Consultation Response from KC Landscape	
Application No:	2023/93503
Proposed Development:	Outline application for residential development of 82 dwelling and associated works, with layout and access as considerations
Location:	Land off, Roslyn Avenue, Netherton, Huddersfield, HD4 7EW
Applicant/Agent:	Johnson Mowat Planning & Development Con
Planning Officer	Nick Hirst
Date Responded:	18.01.2024, updated 29.01.2024
Responding Officer:	EM
Responding Ref:	MM113 rev 1

Proposed Site Layout - NTS

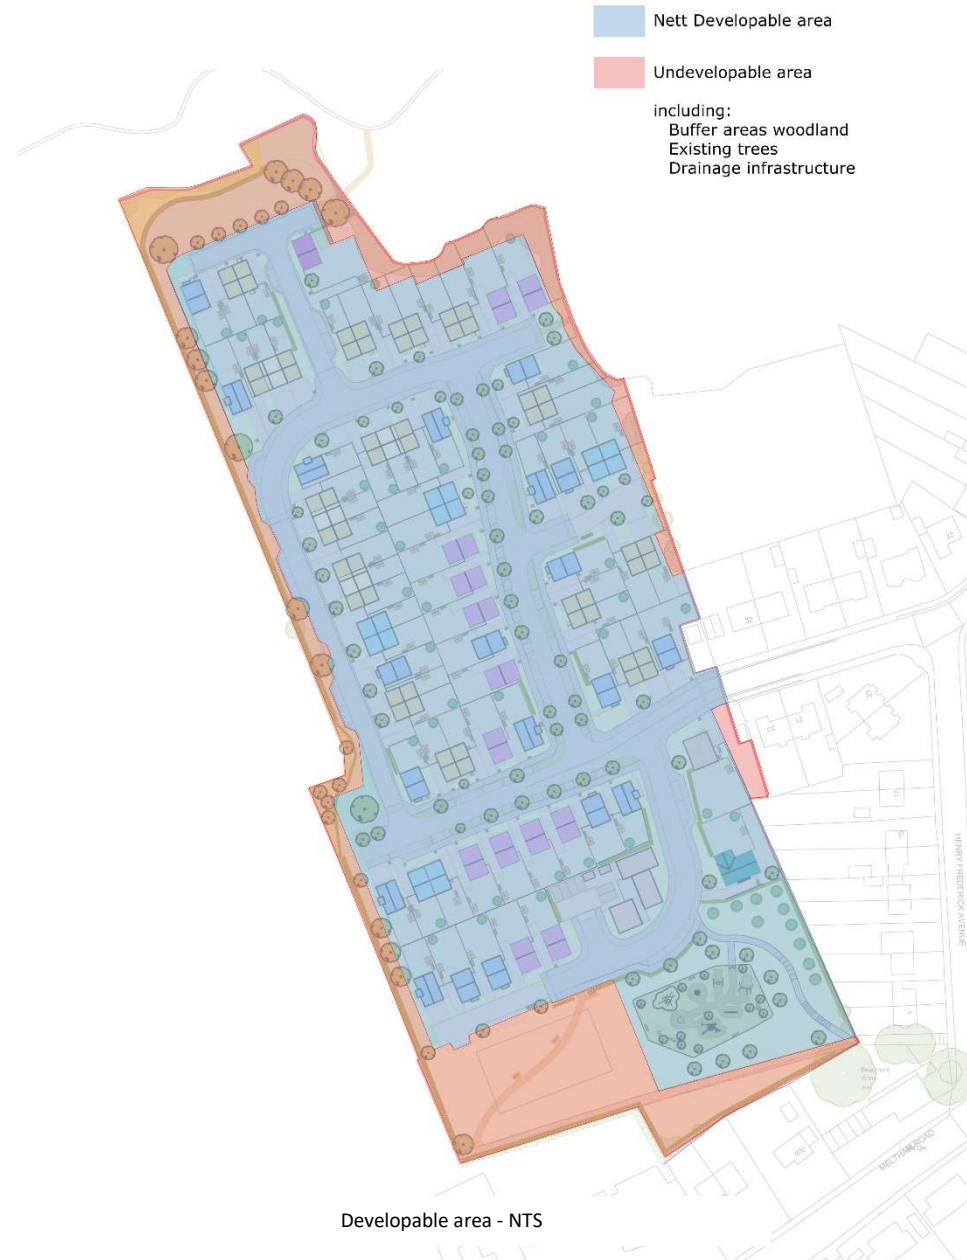
2. Greenspace on site is welcome, however, with regards the typologies, we would question if the location of a parks and recreation area over the attenuation tank meets the criteria. We will need cross sections and details of surface treatment, any inspection chambers etc to be satisfied this would be a recreational area for public use, and to be mapped as such on the Kirklees mapping system as a public park & recreation area. At present it does not meet the Park criteria – even as a pocket park. We cannot label it as a “Park” on the Kirklees map as a park for the public to visit, it looks more like a grass space.

3. In addition, given the usual constraints of an attenuation role, will the open space provided and annotated as recreation, meet the needs of the widest possible range of users, be easily accessible and enjoyed by all people, regardless of visual, physical and cognitive ability, mobility or age? There are no paths, planting or designed infrastructure for users.

5. The curtilage and adjacent Public Open Space should be better defined to ensure that there is a clear definition of residential/amenity use and there should be an appropriate emphasis in landscape design terms. Defensible space is important and needs considering carefully as secure by design.

This area is ambiguous, it is shown as dark green N&SN greenspace, however there is no clear curtilage boundary to the orchard POS nor garden, driveway, just sloping grass banking.

And clarity on the defensible space along these curtilage boundaries butting up to the POS areas marked as N&SN greenspace.
